From: Planning Department <planning@wlma.org.uk>
Sent: 27 March 2026 11:58
To: Niland, Mark
Cc: _planningadvice
Subject: RE: South Holland DC Planning

Our ref: 25_30828_P
Your ref: H22-0077-25

H22-0077-25 - Land off Broadgate

We have been asked to forward the applicant's response to the points raised in your correspondence, specifically in relation to the surface water discharge strategy and watercourse connectivity.

DRAWING NUMBER
622-S11-00-SI-SK-C-9000

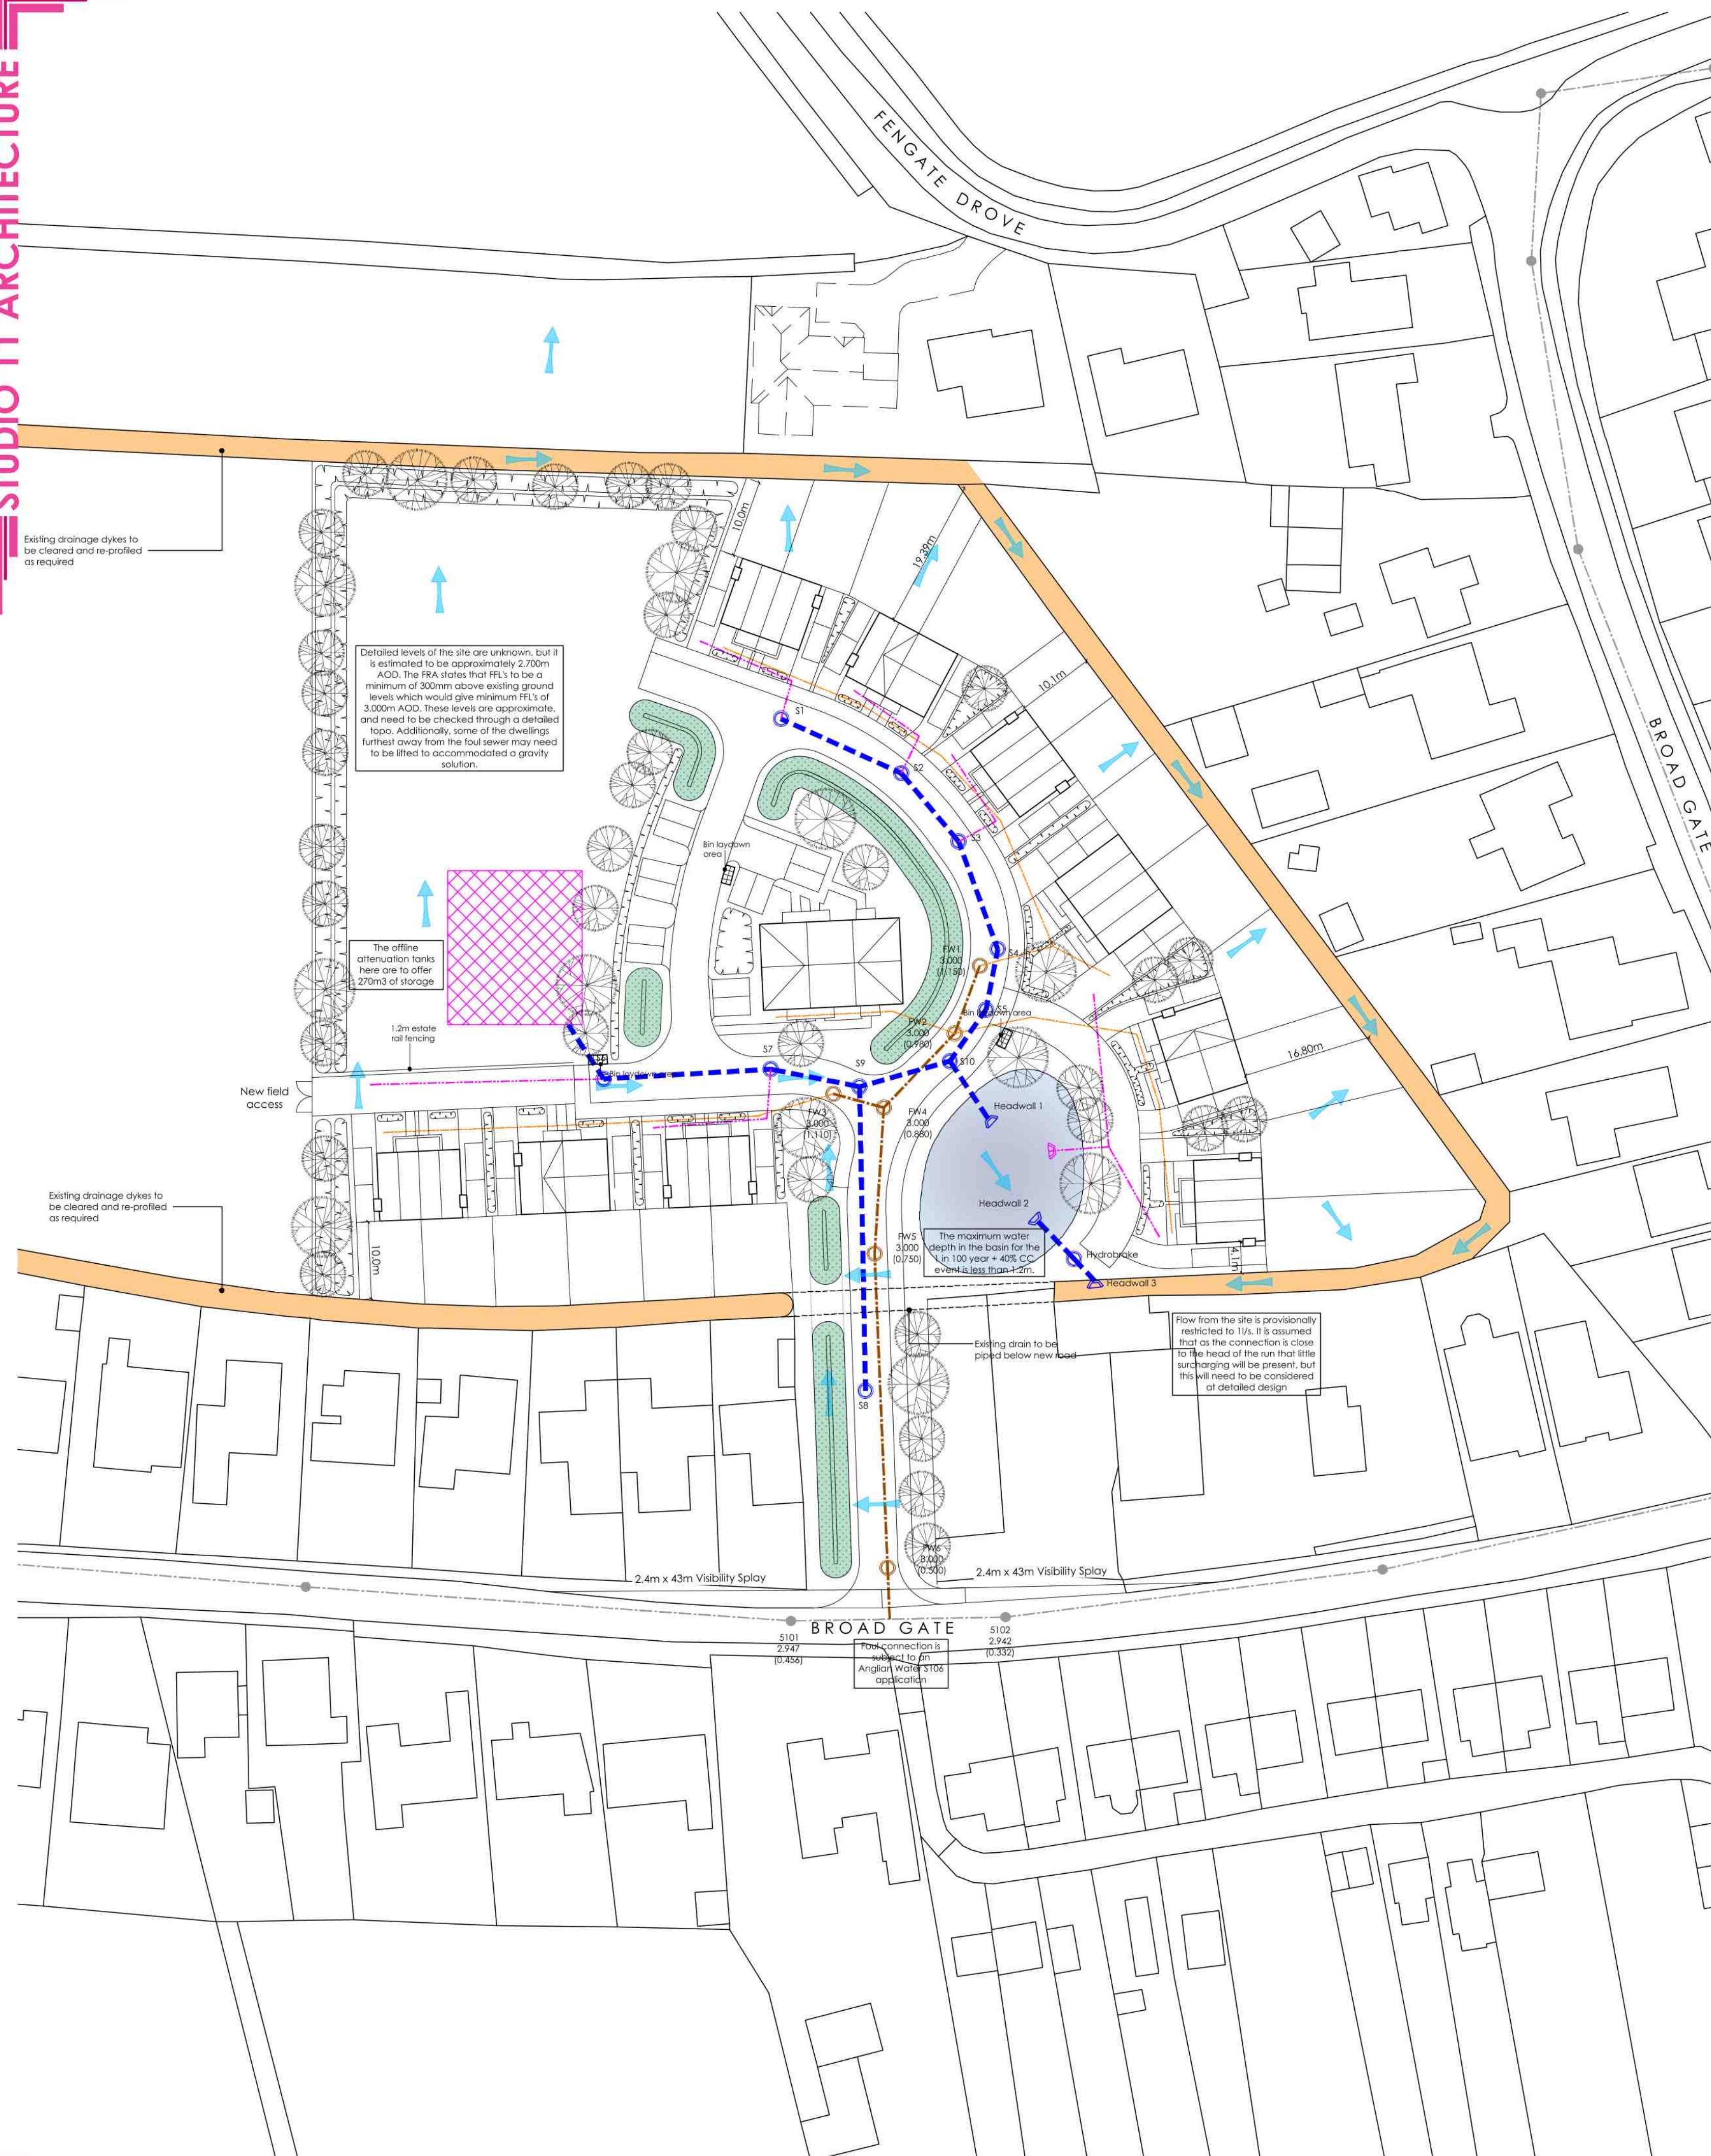
We are happy for the condition of the culvert between points A and B to be investigated at the detailed design stage. We would, however, request further information regarding the proposed alternative route is provided. This can also be addressed as part of the detailed design.

- Detailed investigations of the existing culvert between points A and B, including CCTV surveys
 - An appropriately detailed drainage strategy
 - Detailed design drawings for the proposed culvert between points C and D
 - If required, detailed information regarding the alternative route (should the existing culvert between points A and B be in poor condition).
- 3) This point has not been addressed in the email below. As noted in our letter dated 7th January 2026, we remain concerned about the existing drainage issues at the site. The proposed development will restrict access to the watercourse for future maintenance which may increase the risk of flooding issues for the new development and the existing surrounding properties. Our comments and objection to this point therefore remain.

The IDB's letter dated 7th January 2026 states that the connectivity issue at Points C and D has not been addressed. We would respectfully draw the planning authority's attention to the revised Drainage Strategy drawing ref: 622-S11-00-SI-SK-C-9000 Rev A (Studio 11 Architecture, 13th November 2025), which was submitted prior to the IDB's January letter. Rev A clearly shows a new pipe connecting the watercourse at Points C and D beneath the proposed estate road, with the existing open watercourses to be cleaned and reprofiled as necessary. This directly addresses the IDB's concern at this location. It appears this revision was not fully acknowledged in the IDB's subsequent correspondence. The connectivity of the riparian watercourse through the site is therefore addressed in the submitted documents, and this element of the objection should not be treated as outstanding.

Furthermore, should the detailed design stage investigation reveal that the existing Broadgate Road culvert is not in a suitable condition to serve as the outfall, an alternative connection is available. A new surface water sewer could be laid along Broadgate to connect directly to the IDB's drain, removing reliance on the existing culvert entirely. The viability of the drainage strategy is therefore not contingent on the condition of that culvert. A deliverable fallback exists.

The applicant is content to accept a pre-commencement planning condition requiring the submission and approval of a detailed drainage scheme, including investigation of the Broadgate Road culvert and, if necessary, the design of a replacement connection before development commences. This is the appropriate and proportionate mechanism to resolve this matter, and it gives the IDB full opportunity to scrutinise and consent the connection under their regulatory regime at the right stage in the process.
